Our Ref: TR050007

Date: 22 September 2023

**Application by Tritax Symmetry (Hinckley) Limited for an Order Granting Development Consent for the Hinckley National Rail Freight Interchange**

## Link ID - Sheet 11

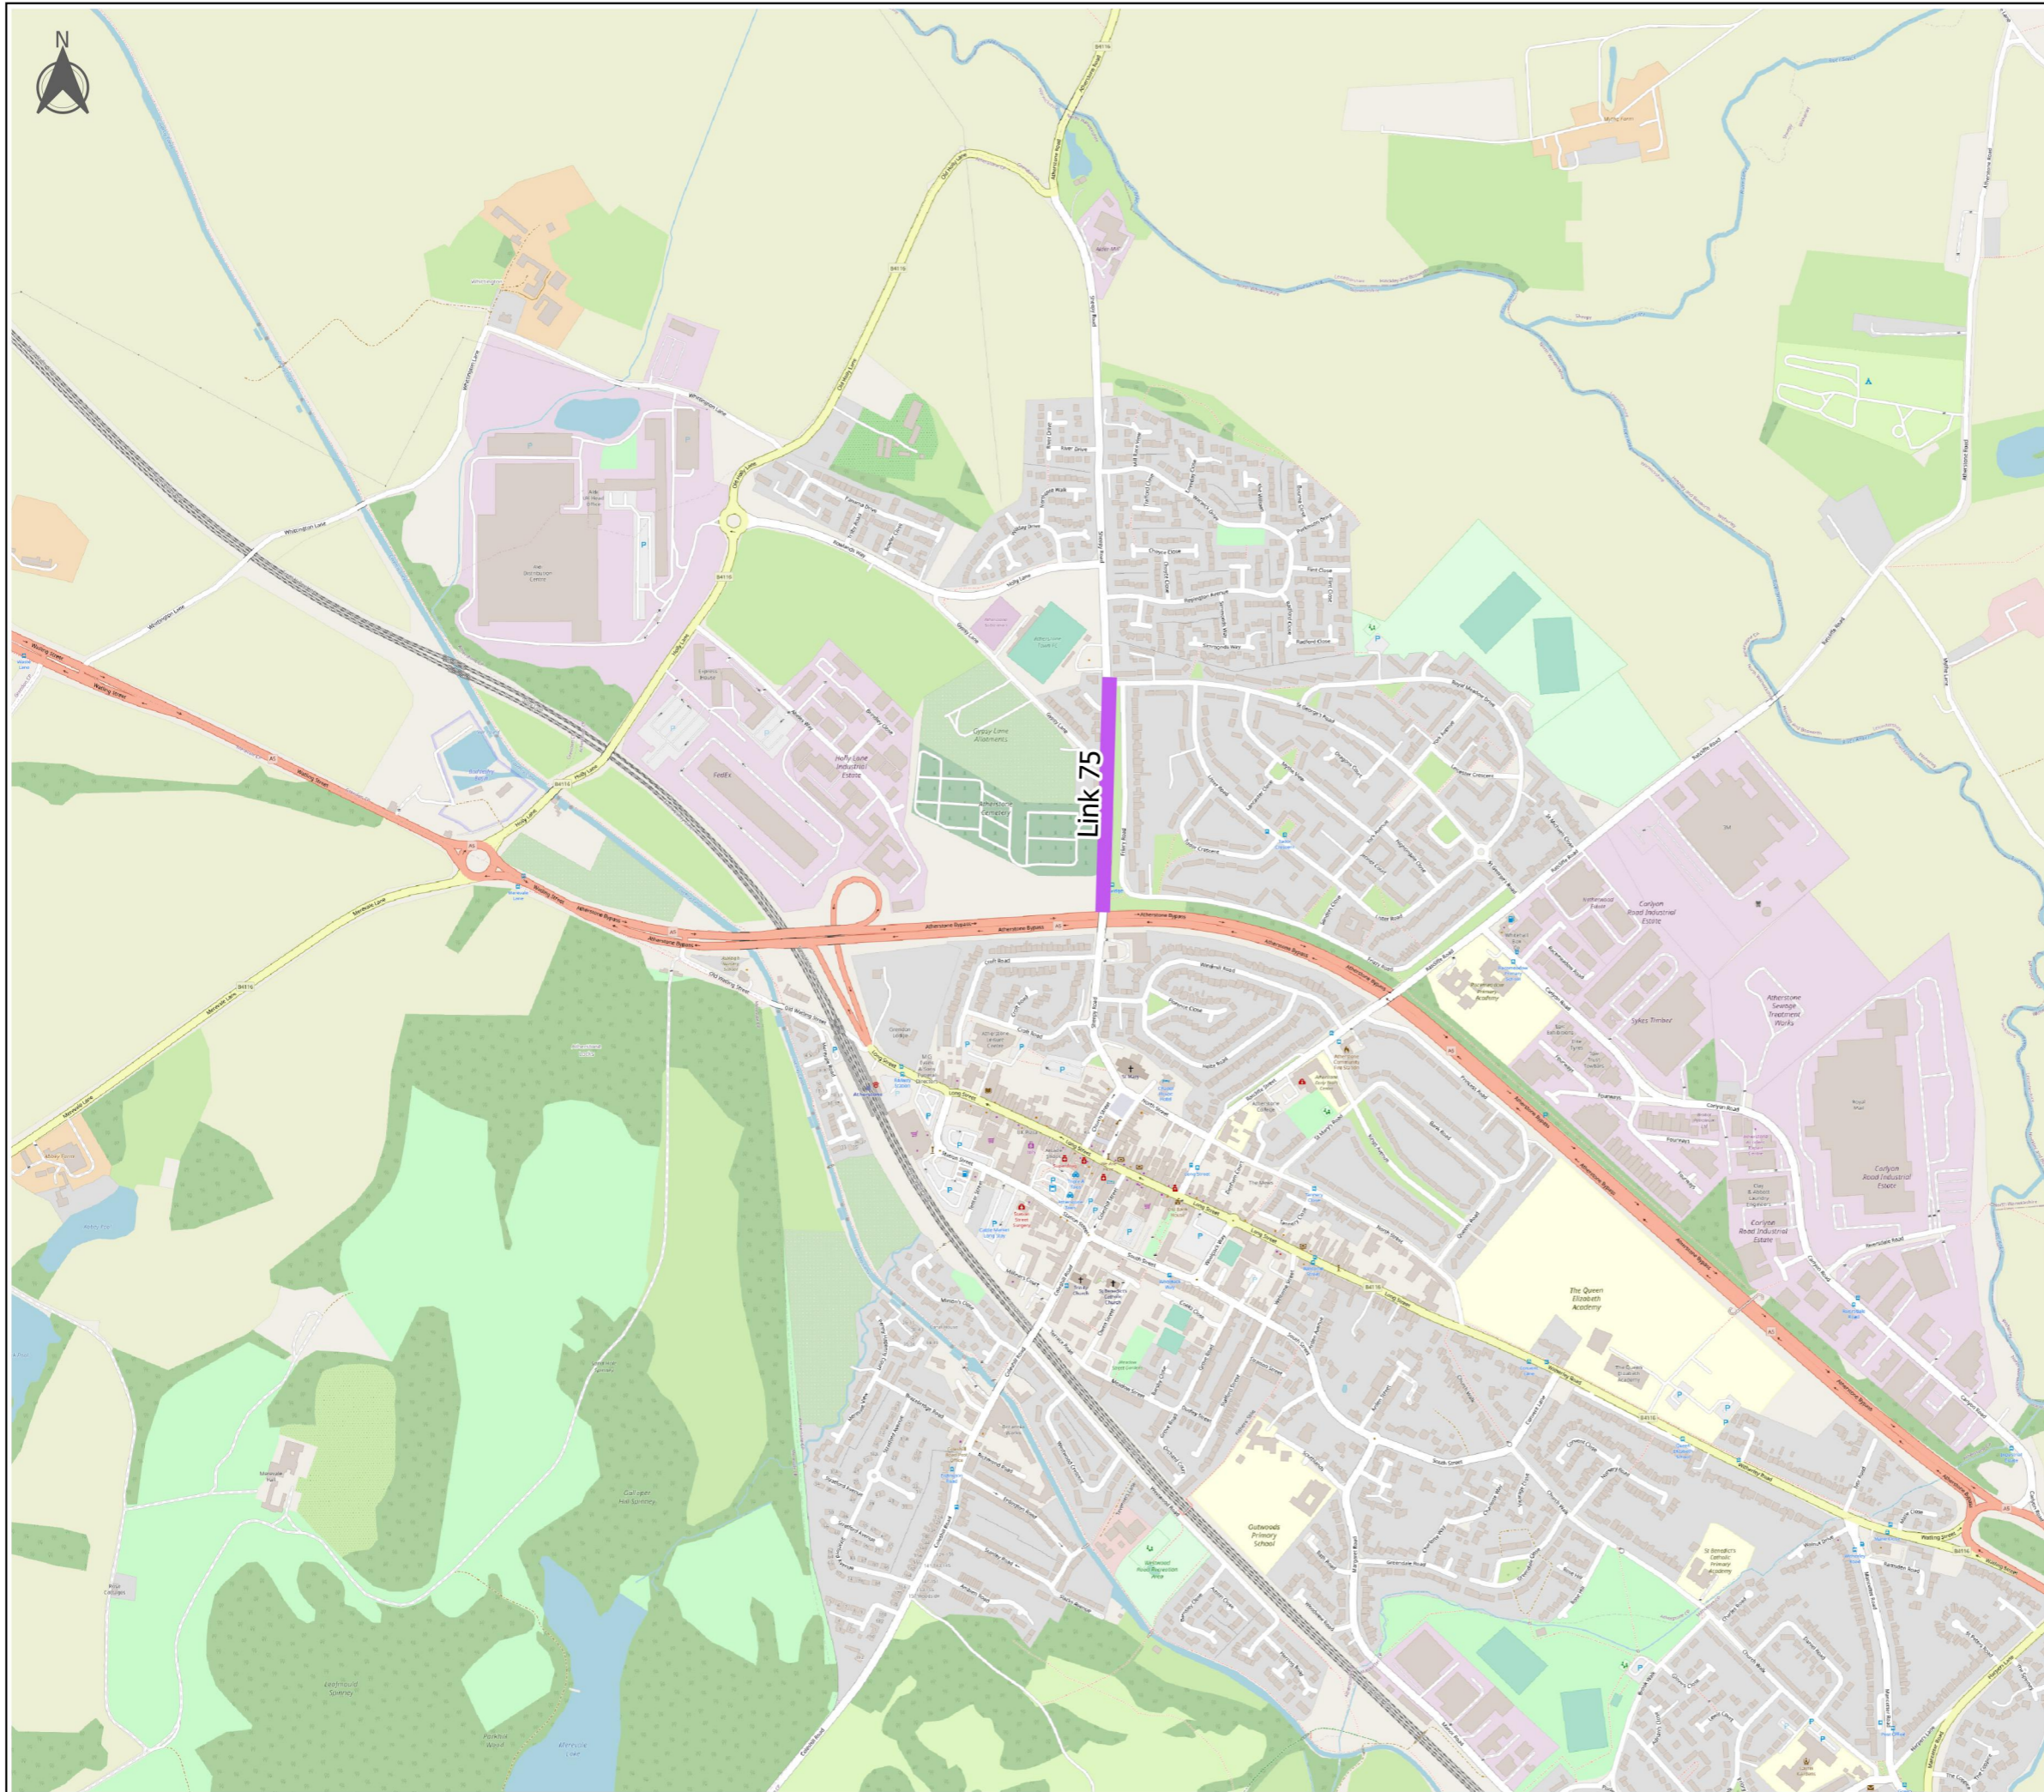
Table 8.3 of Chapter 8 of the Environmental Statement [APP-117] sets out a list of the Links to be assessed and Paragraph 8.292 sets out roads where there would be adverse effects from the Proposed Development. Could these both be shown graphically on maps to an Ordnance Survey base at a scale of 1:10,000 or less, with the end points of the links made clear.
